Rosefield Solar Farm

Schedule of Changes to the draft DCO (Tracked)

EN010158/APP/8.1.98
Revision 0908
Deadline 76
August 2026
Rosefield Energyfarm Limited

Schedule of Changes to the draft DCO

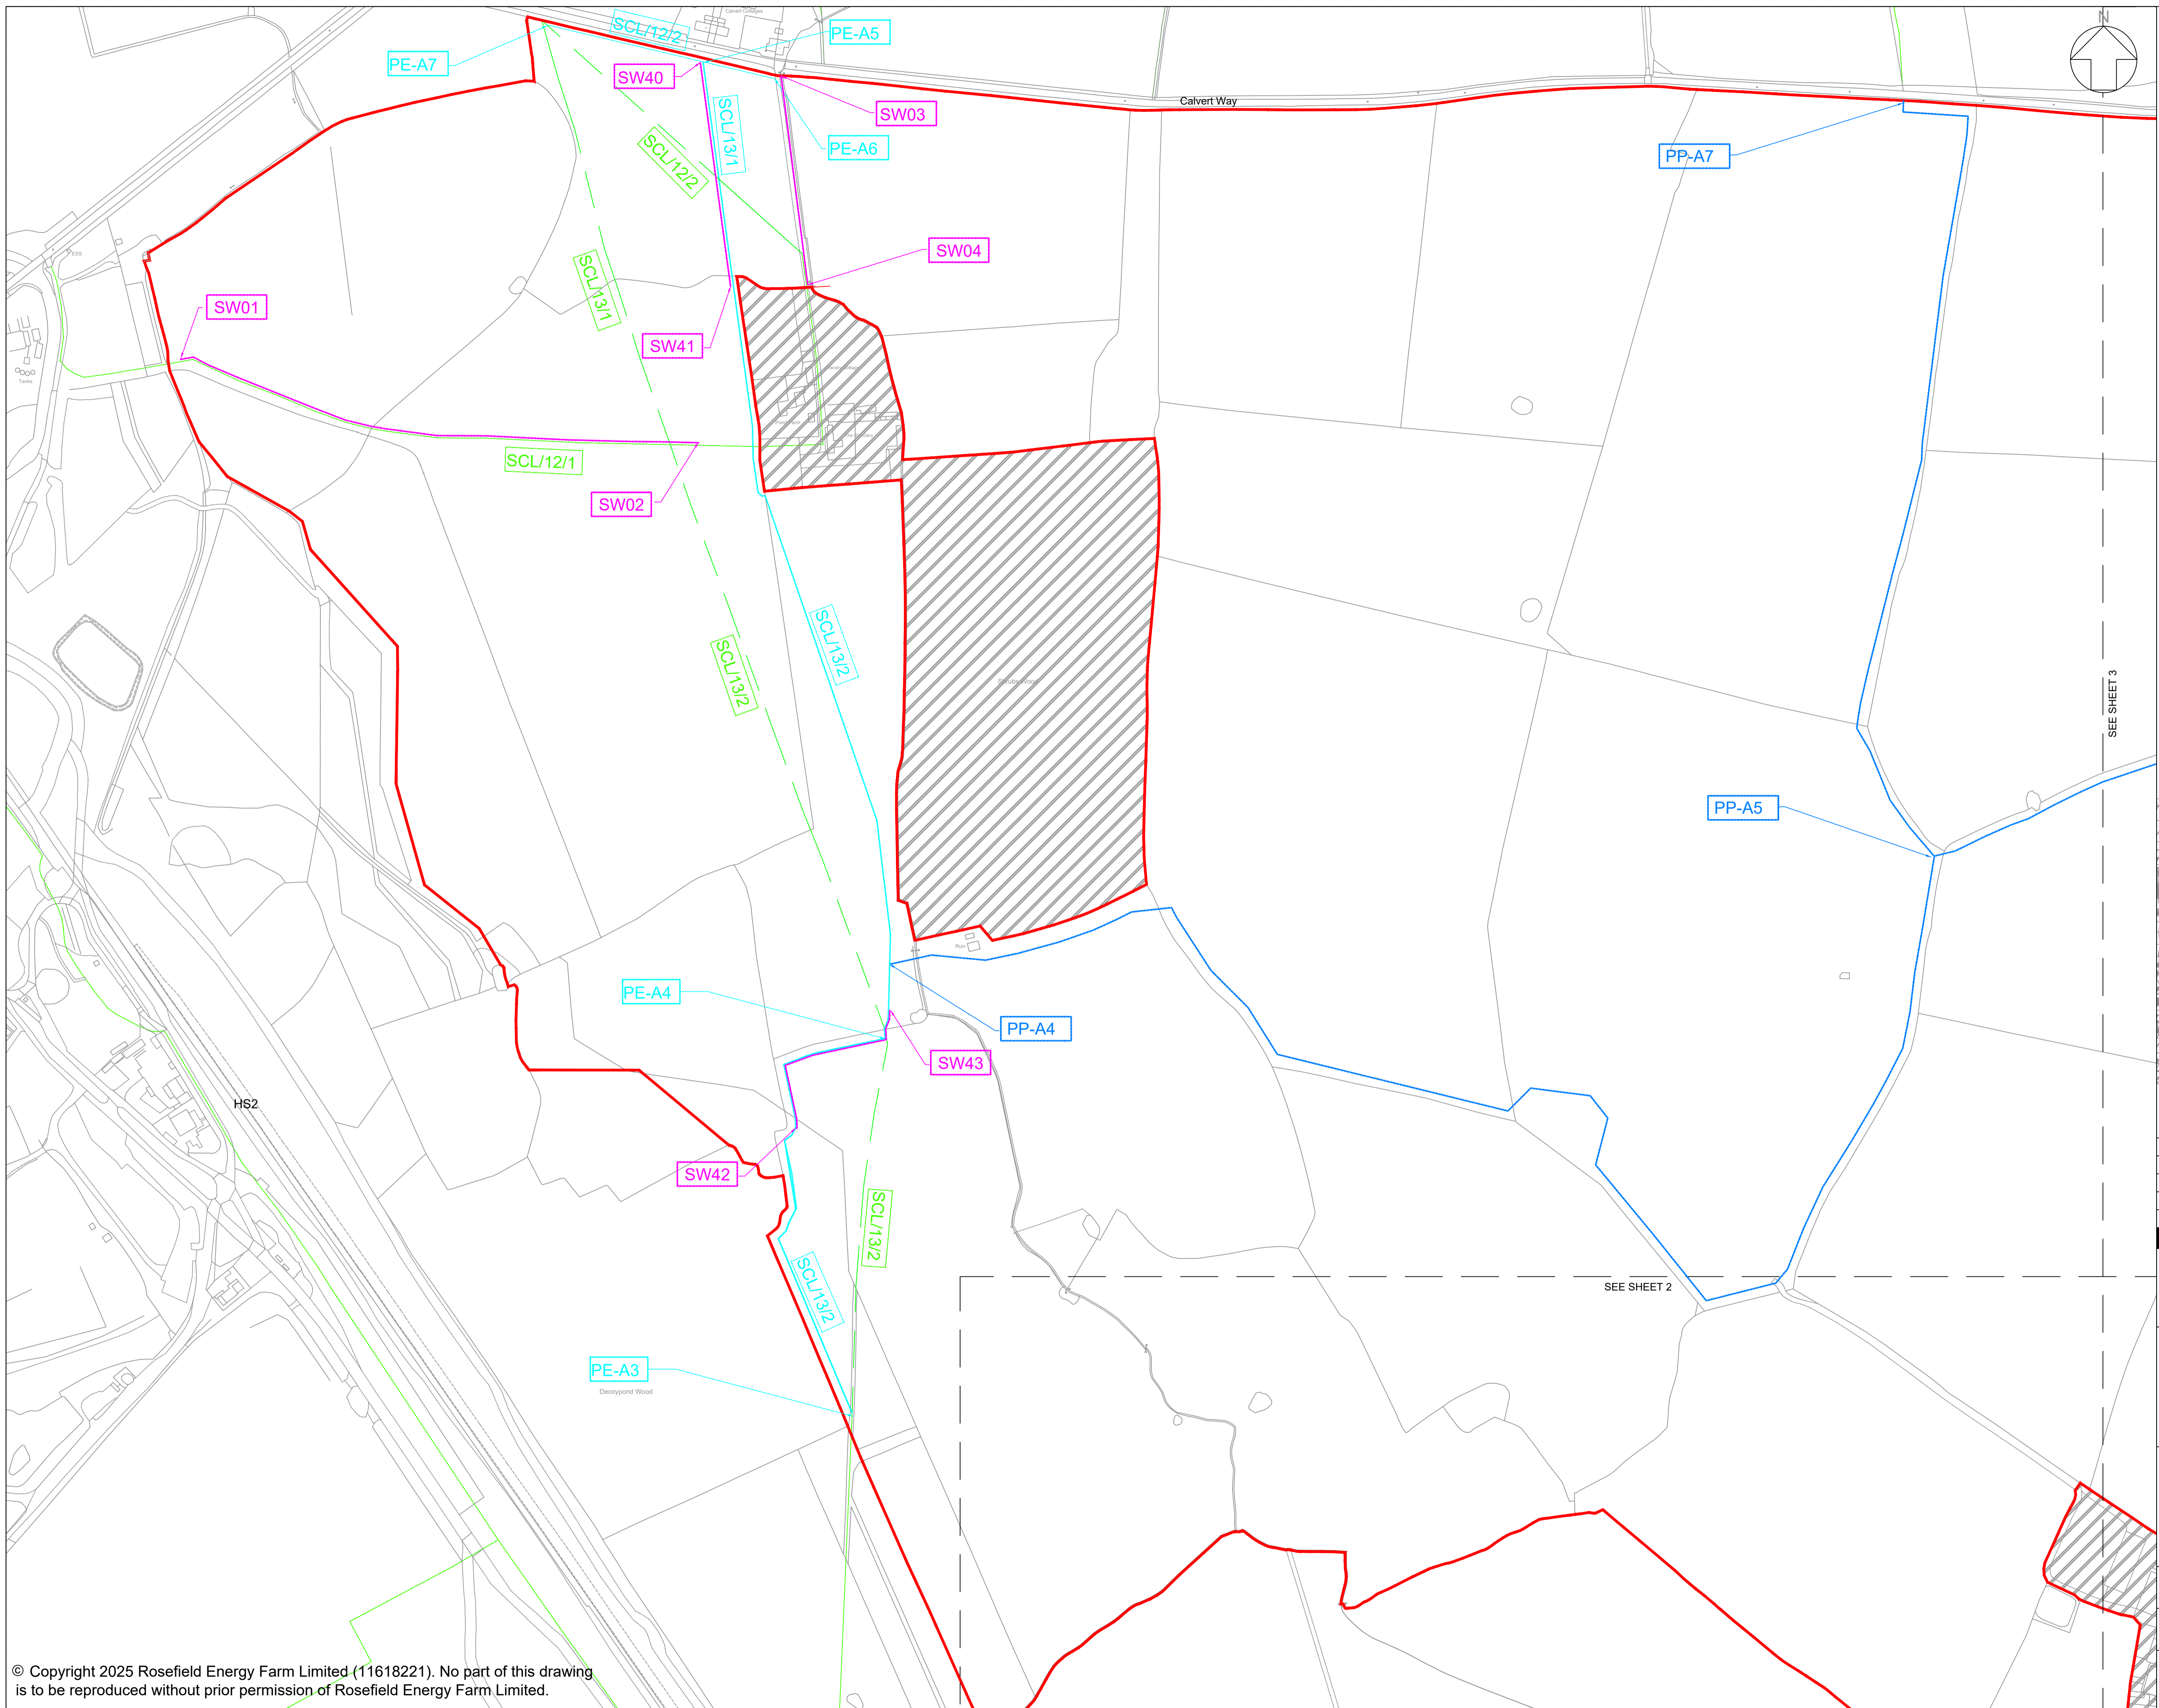
District of Buckinghamshire	SCL/13/1 and SCL/13/2	For a distance of 1,210 metres between points PE-A7 and PE-A3 as shown on sheet 1 of the streets, access and rights of way plans.	New public footpath of minimum width of 2m to be provided between points PE-A7, PE-A5 and PE-A4 and PE-A3 as shown by a cyan line on sheet 1 of the streets, rights of way and access plans.		
	District of Buckinghamshire	SCL/12/2	For a distance of 190 metres between points PE-A7 and point PE-A10 as shown on sheet 1 of the streets, access and rights of way plans.	New public footpath of minimum width of 2m to be provided between points PE-A7, PE-A5 and its intersection with SCL/12/1 as shown by a cyan line on sheet 1 of the streets, rights of way and access plans.

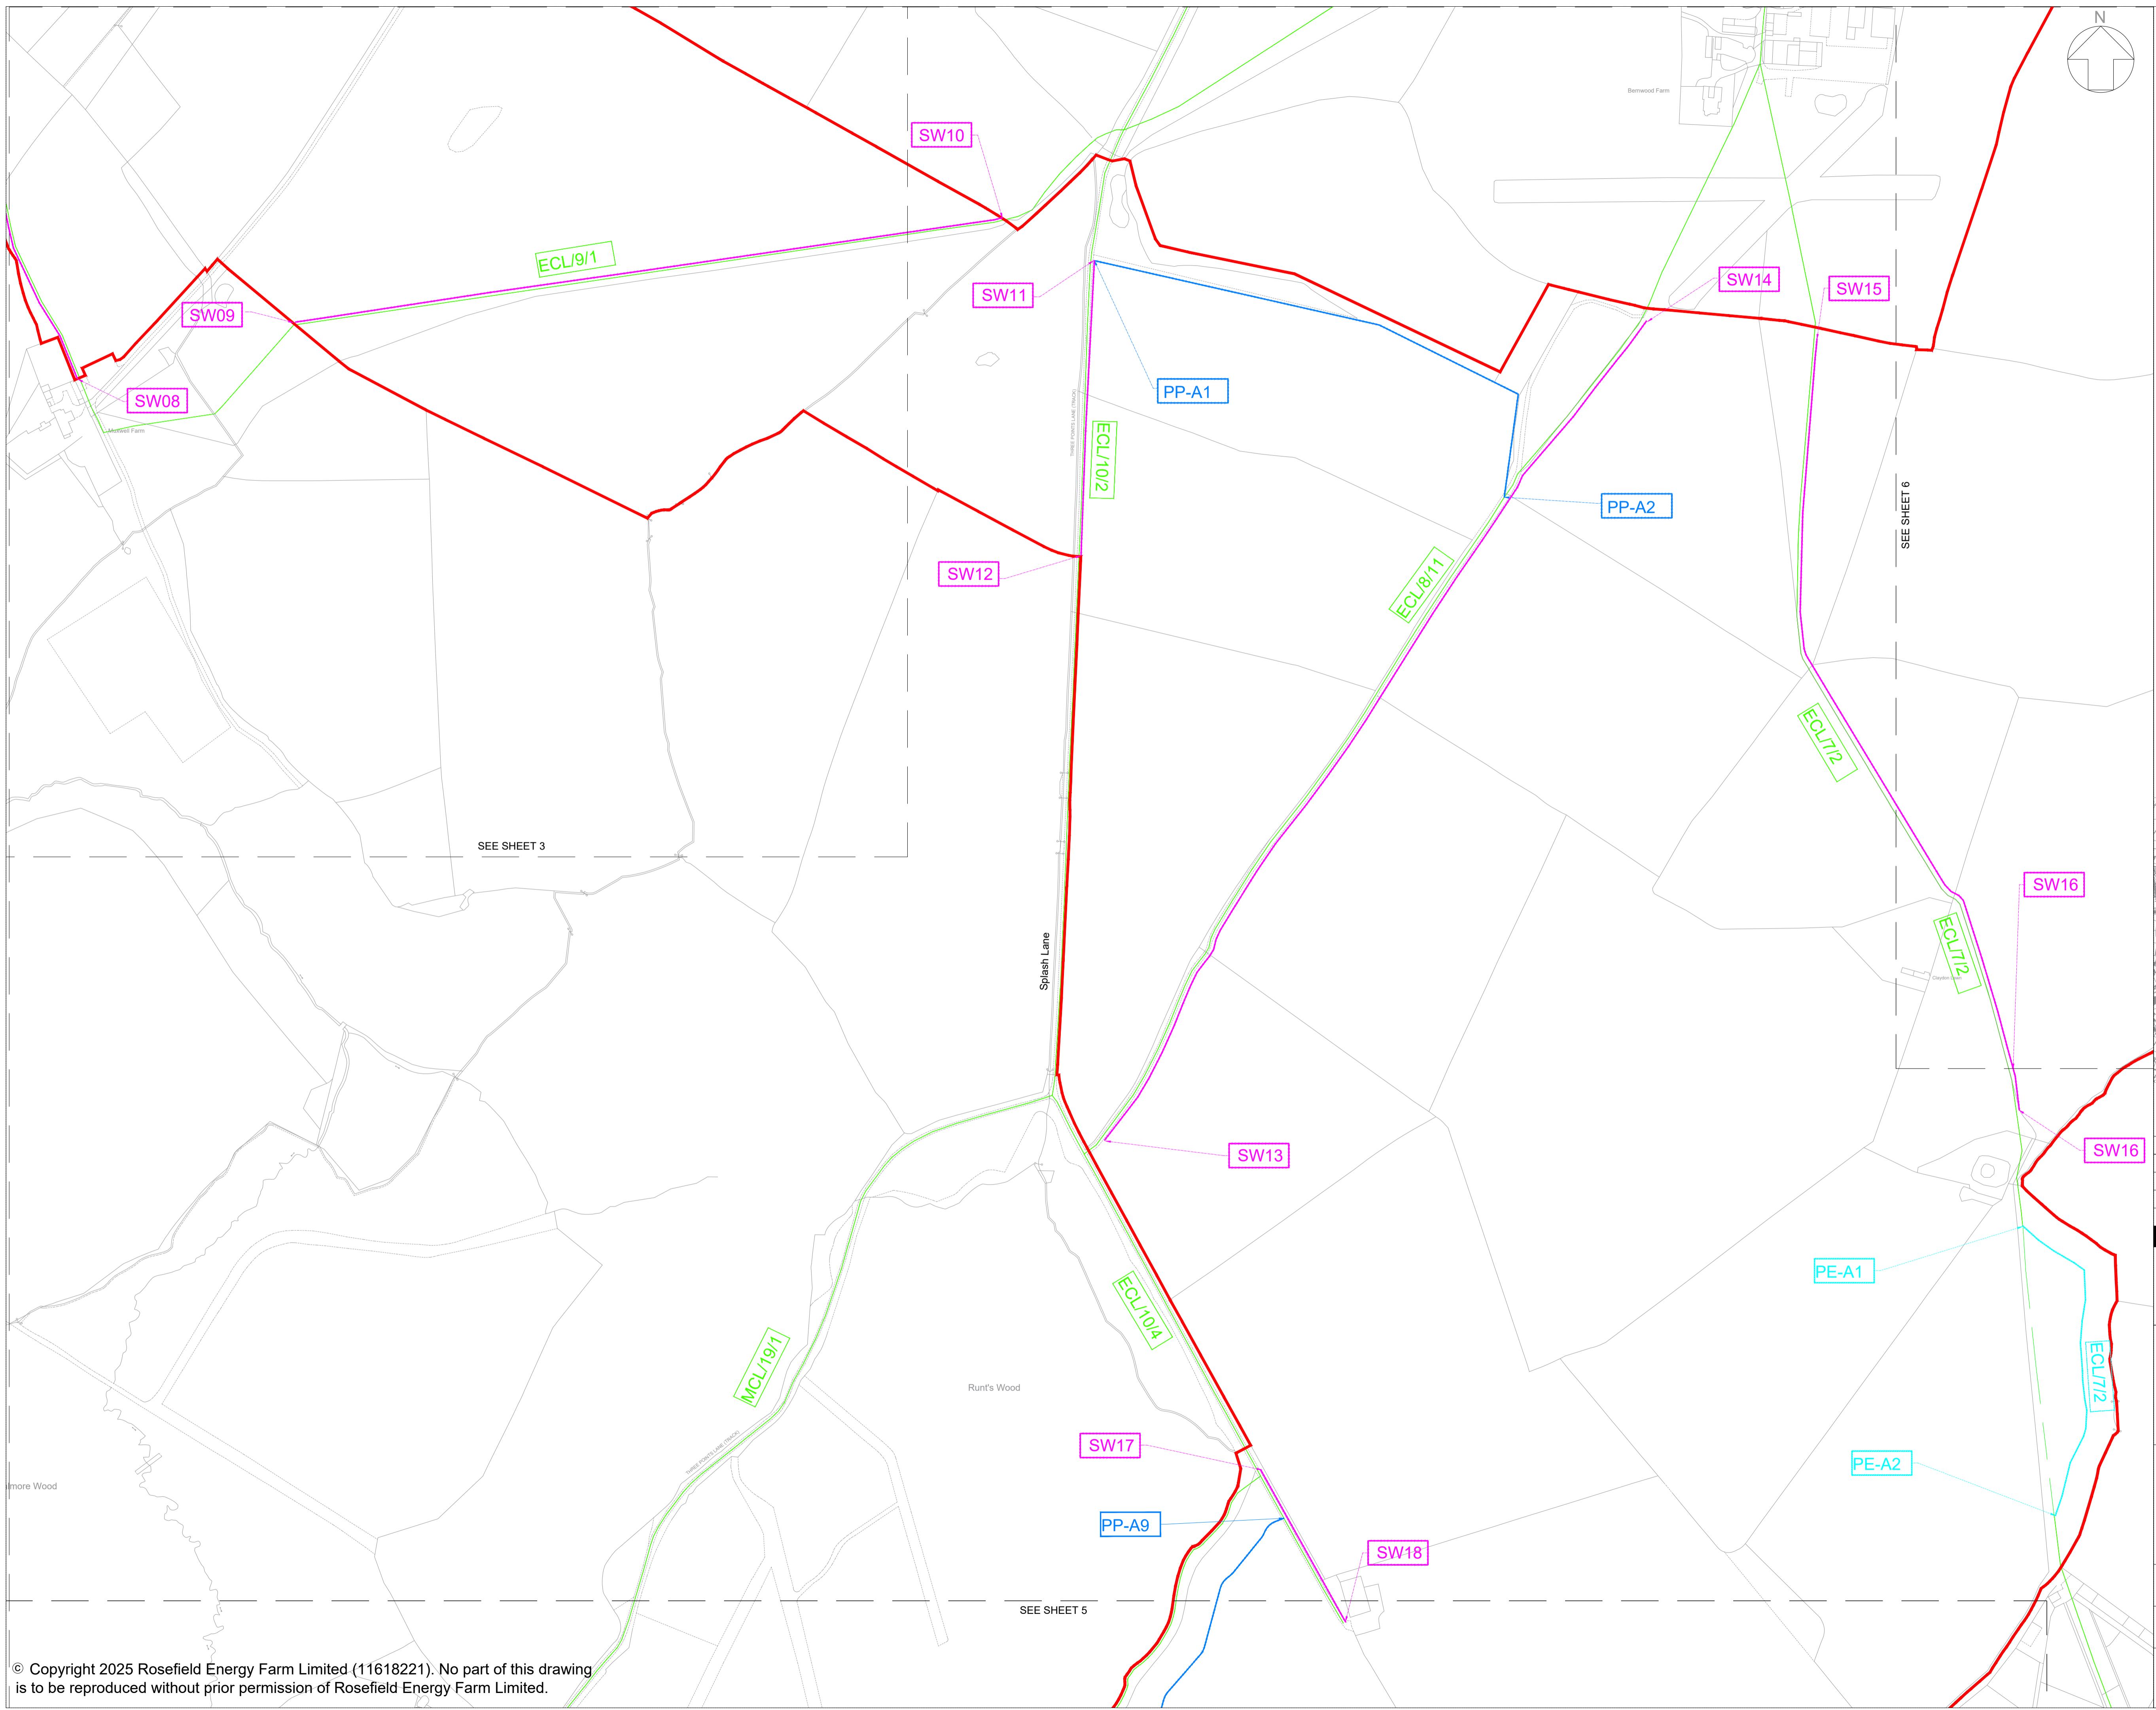
Reference	Change				Reason for Change	Deadline
	District of Buckinghamshire	ECL/7/2	For a distance of 243 metres between points PE-A1 and PE-A2 as shown on sheet 4 of the streets, access and rights of way plans.	New public footpath of minimum width of 2m to be provided between points PE-A1 and PE-A2 as shown by a cyan line on sheet 4 of the streets, rights of way and access plans.		
	District of Buckinghamshire	ECL/4/2	For a distance of 463 metres between points PE-A8 and PE-A9 as shown on sheet 7 of the streets, access and rights of way plans.	New public footpath of minimum width of 2m to be provided between points PE-A8 and PE-A9 as shown by a cyan line on sheet 7 of the streets, rights of way and access plans.		
Schedule 16, 2(1) (Applications made under requirement)	For an application for discharge of a requirement to be valid, the undertaker must provide the following information to the relevant planning authority electronically via email (unless otherwise agreed between the parties in writing)—				The below updates to Schedule 16 have been made in response to comments in Buckinghamshire Council's Local Impact Report [REP1-112] and following further engagement with the Council following ISH1. Amendments reflect the approach	4
